Add PCD File No. CS203

Master Traffic Impact study

RE: SH 94/Curtis Road
Traffic Impact Study
El Paso County, Colorado
LSC #204310

Figure 2

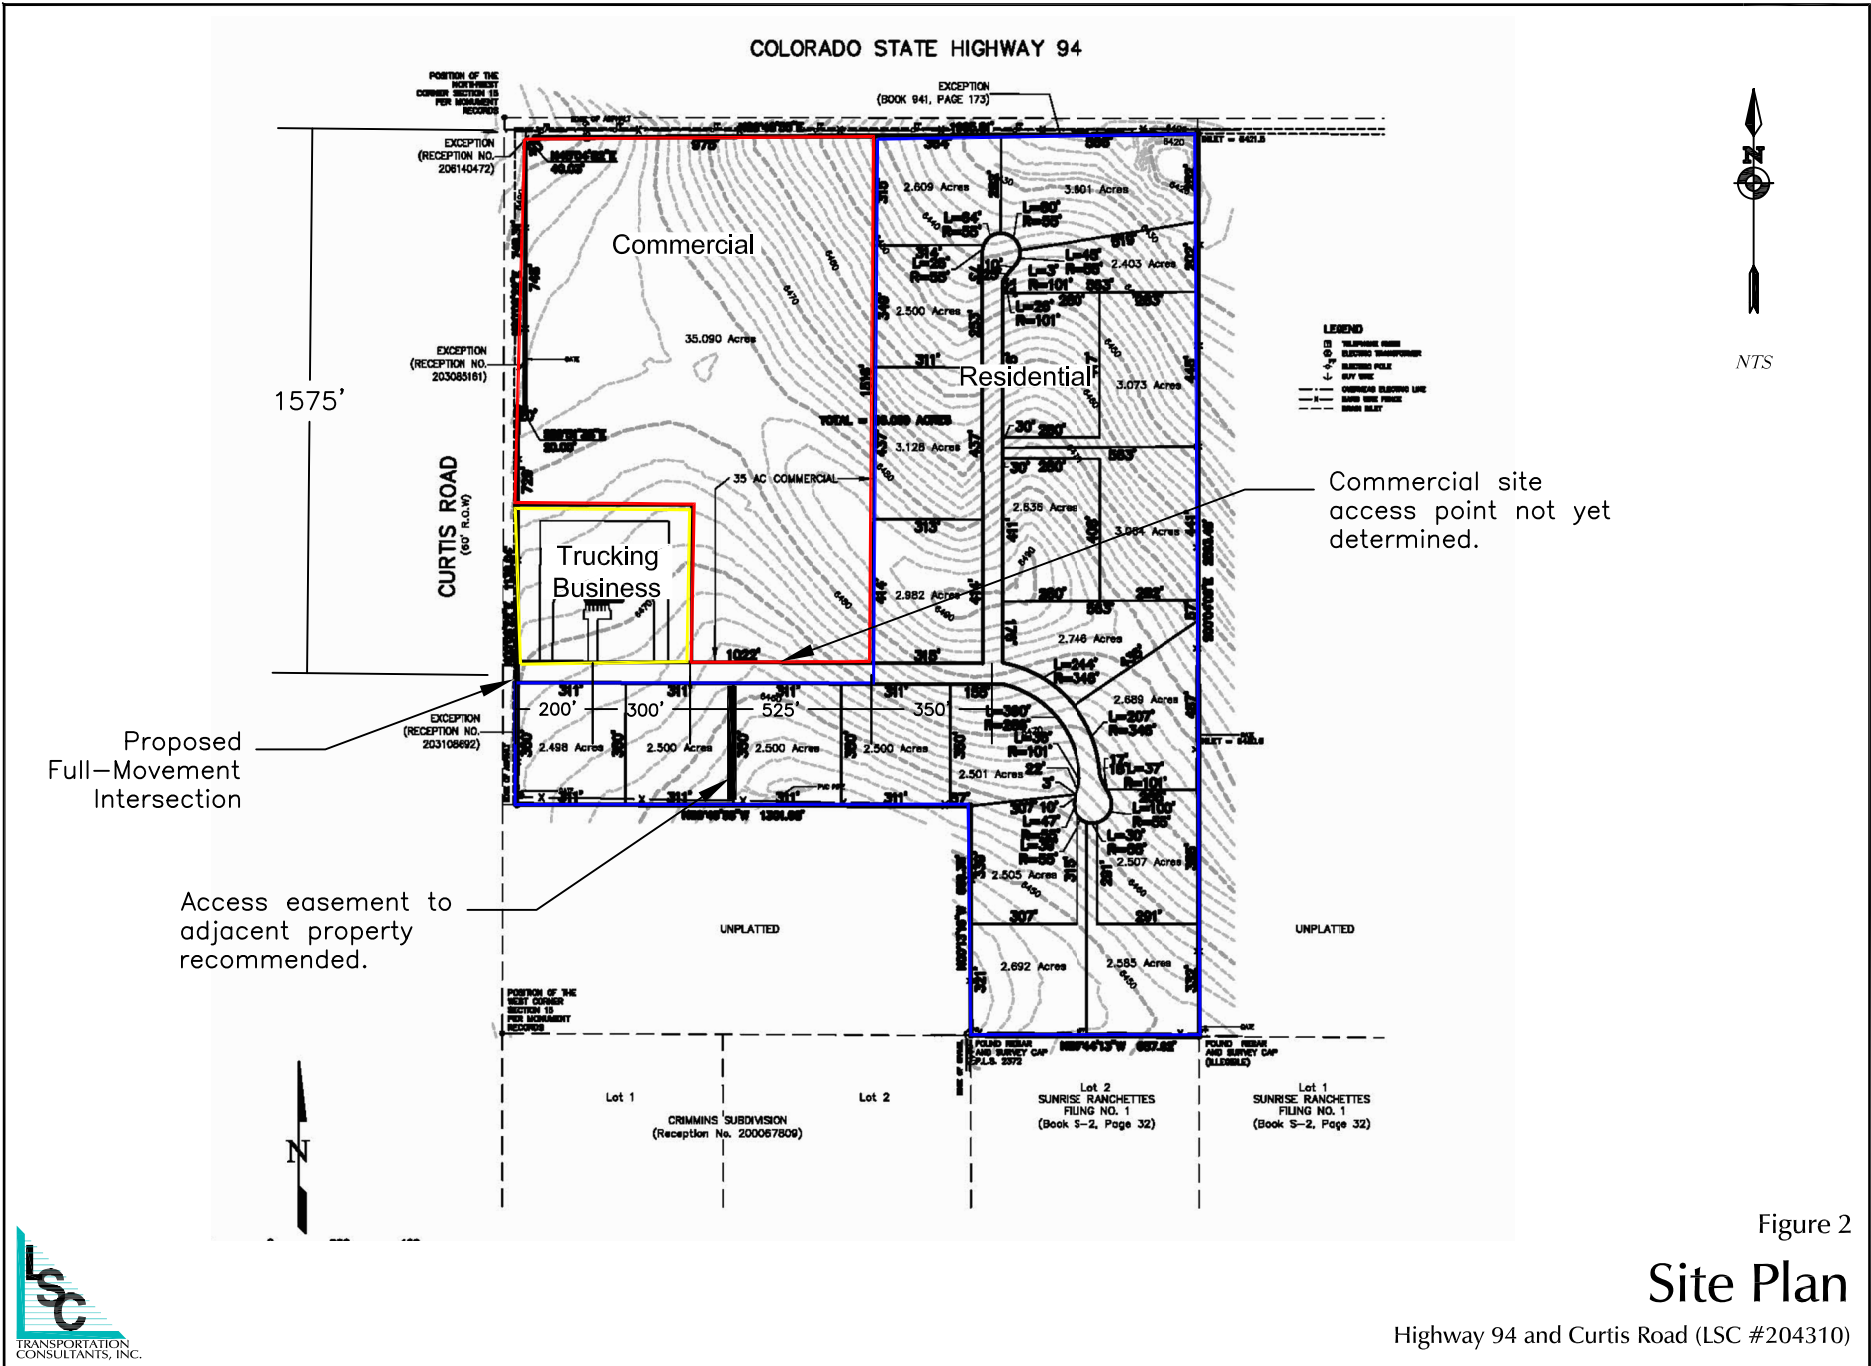
Based on the trip generation, the roadway would be a higher classification. Please indicate what the roadway classification would be based on the proposed trip generation and explain your reasoning for indicating that it be a rural local roadway.

The site plan recommends an access to the southerly property. Please include that in your narrative.

Figure 6
Phase 1 Trip Distribution
and Site-Generated Traffic

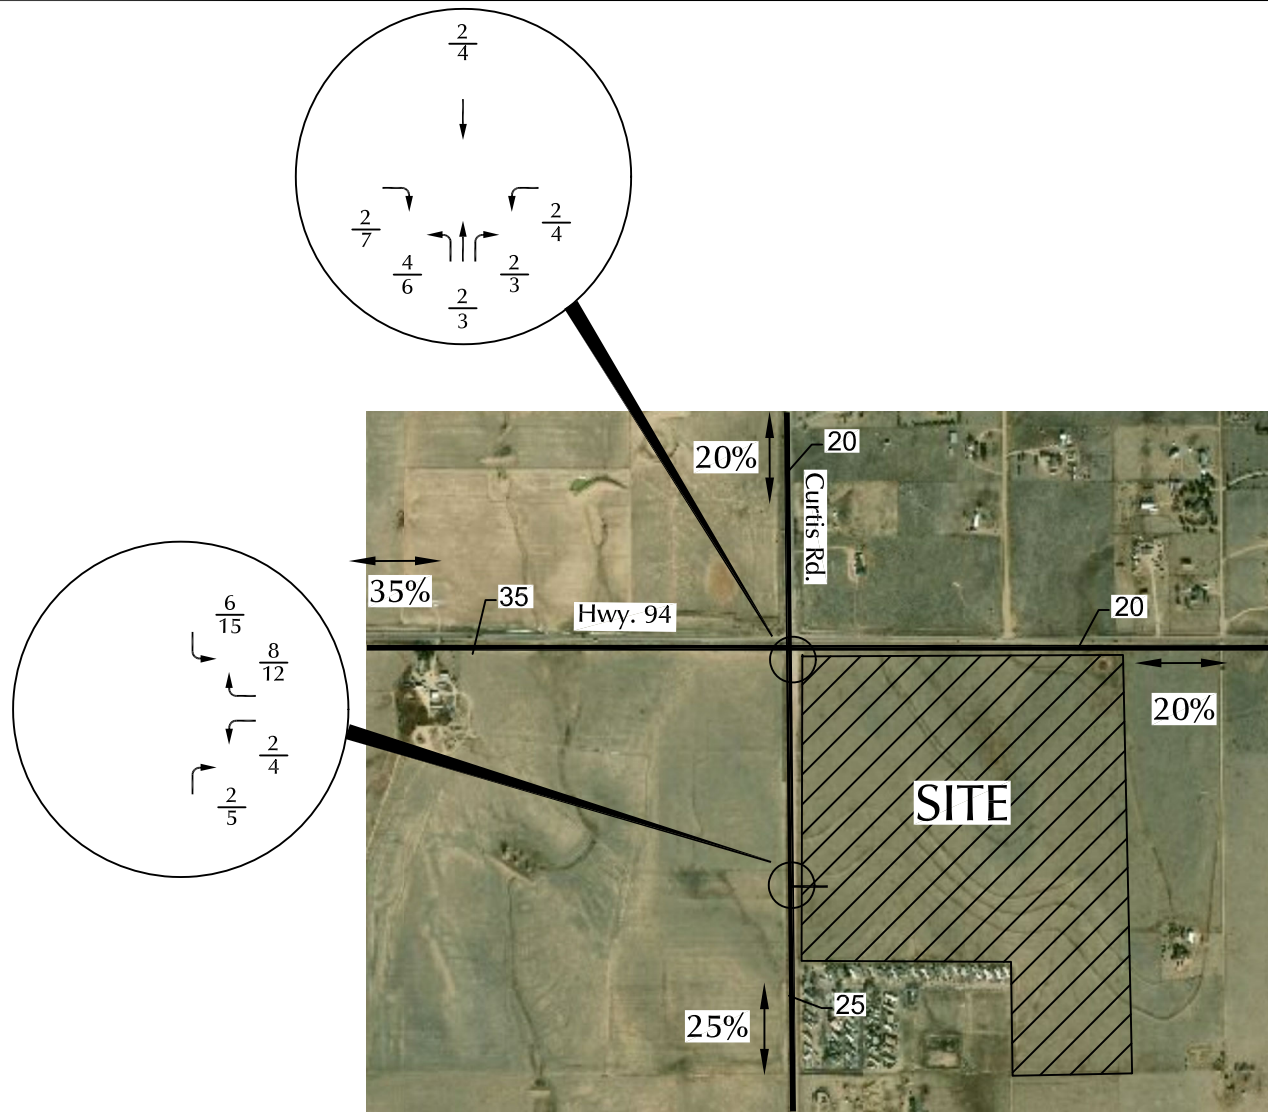
Please elaborate on your reasoning for the trip distribution you provided.
